Address: Mill Barn, 27 Clay Well Huddersfield HD7 4JD

Application number: 2021/93621	
What is the application for?:	Erection of 10 dwellings and associated works (Within a Conservation Area)
Address of the site or building:	Land off, Fullwood Drive, Golcar, Huddersfield, HD7 4JH
Postcode:

Description: PROPOSED SITE PLAN & 3D VIEW

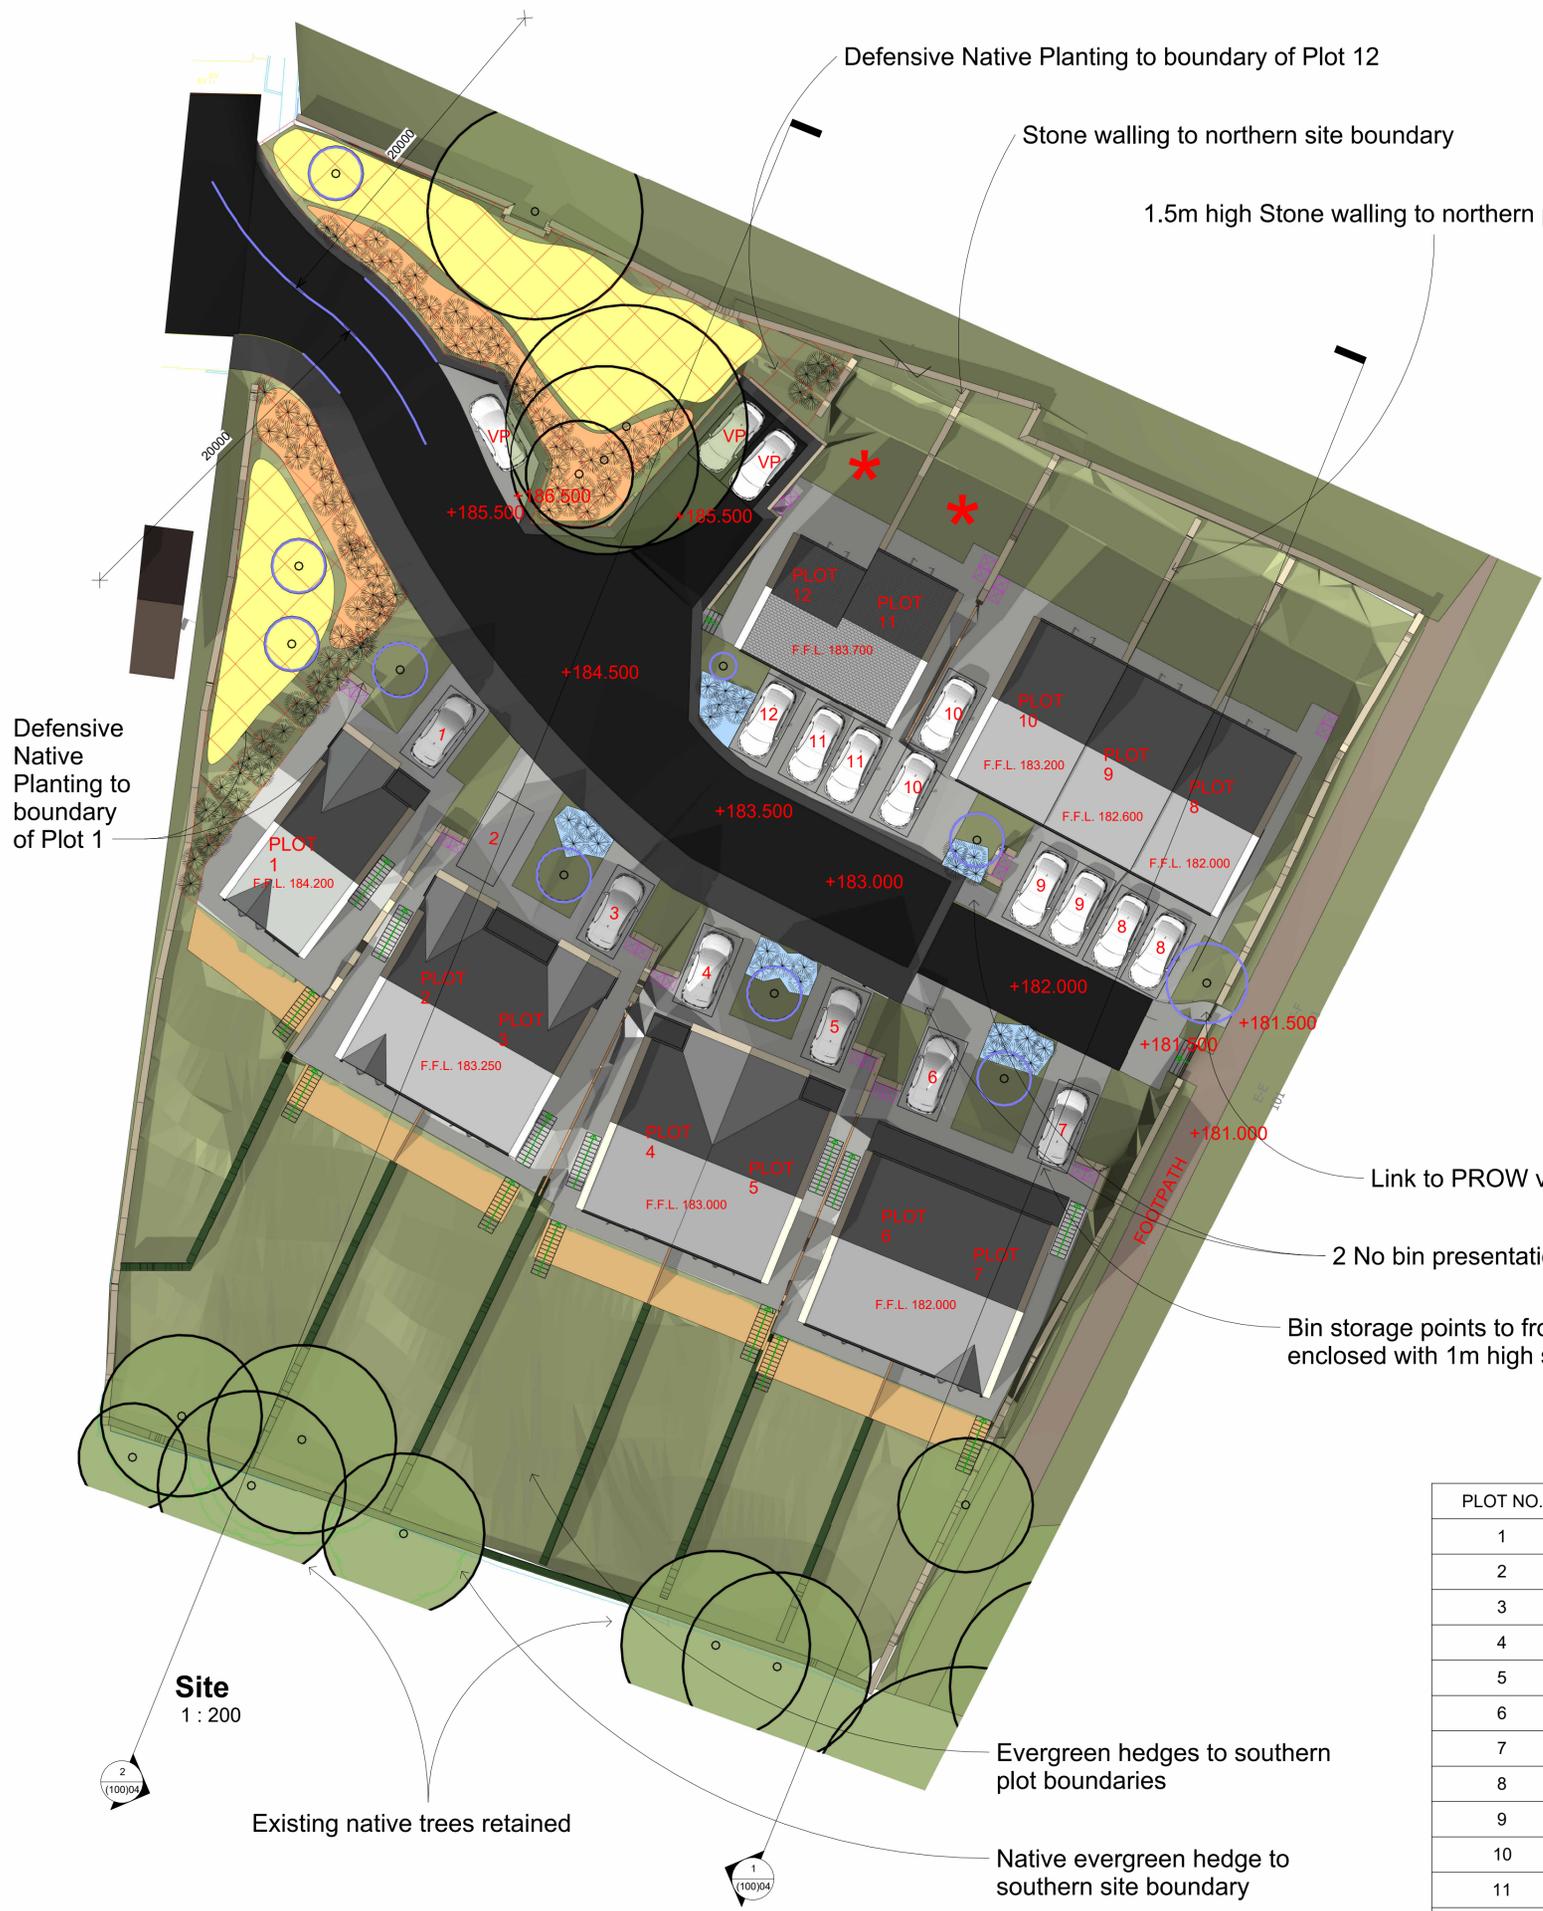
new houses compared to the current submitted plans that have the rear of the buildings now facing our property (and significantly taller)

The new application incorporates up to 4 storey buildings on very substantial footings (Plots 6 – 10) which all contributes to having a severe impact on the current housing and a much greater loss of privacy.

So if the houses could be reverted to the direction on the original plan (left image) and if Plots 9 & 10 could be located below Plots 7 & 8 then there would be no impact to the existing houses and no objections because they would be lower down the hill and not have an effect or be able to see into currently habitable rooms. Because as you can see from the right image which is the current application there is a significant impact on the current Listed Building sited within a Conservation Area.
